Application for Planning Permission for Works or Extension to a Dwelling

Development: Construction of single storey side extension with steps to rear and conversion of garage to habitable use.
Location: 37 Torton Hill Road Arundel BN18 9HF

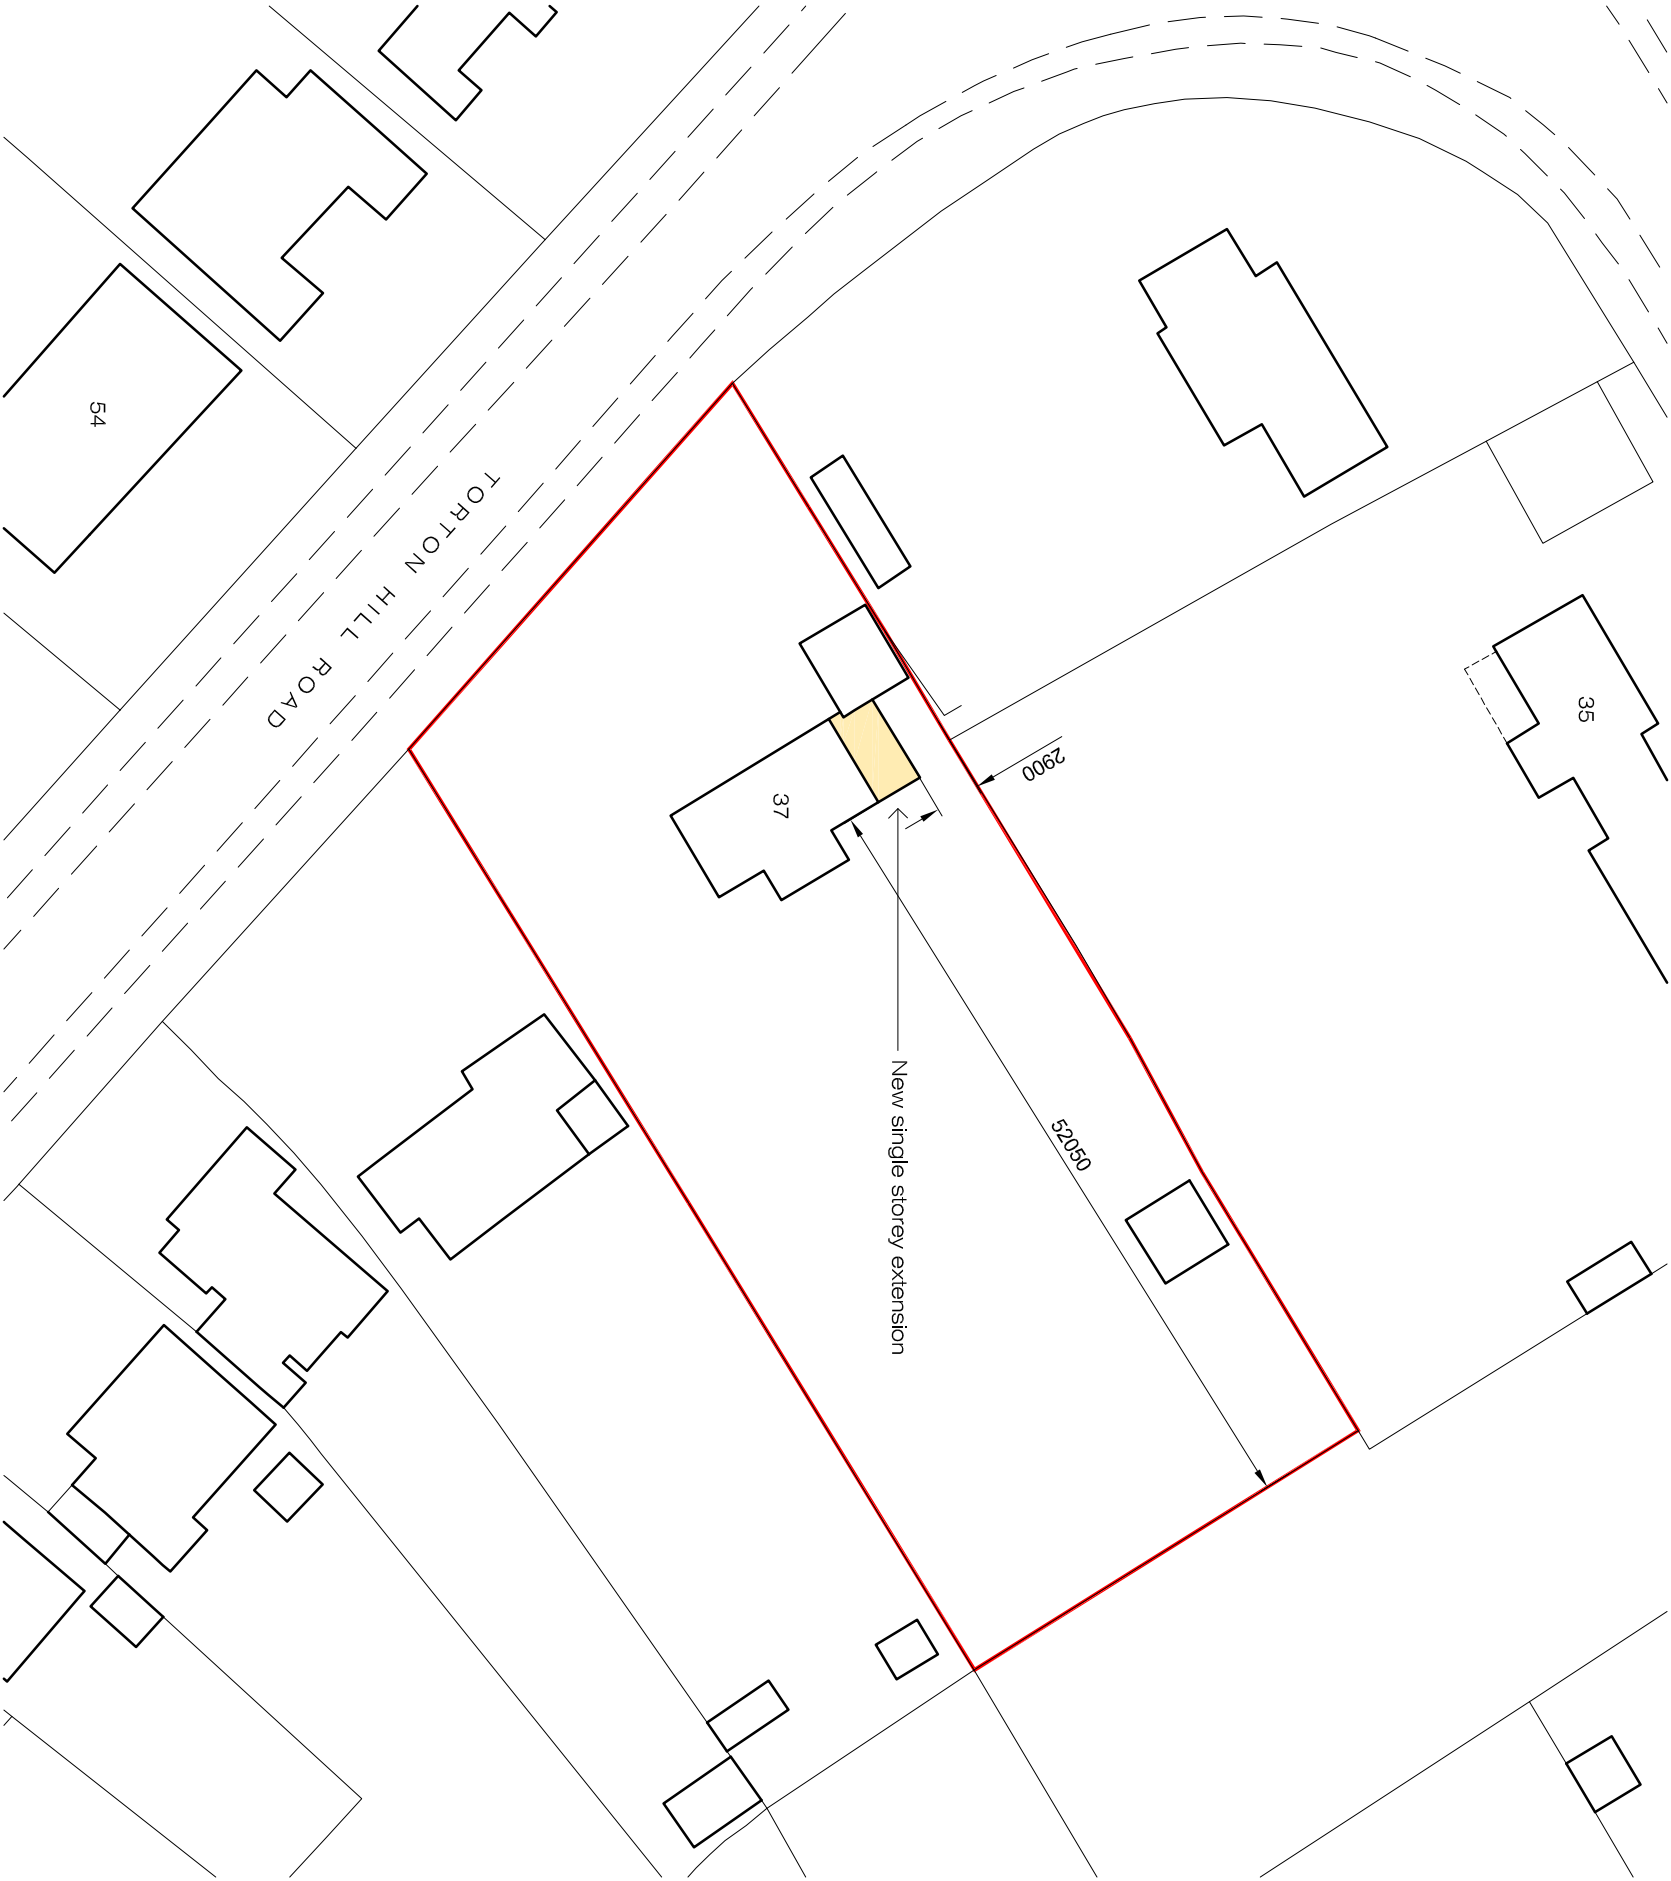
Block Plan

You are required to have dimensions from the proposed extension(s) to all site boundaries. Please amend.
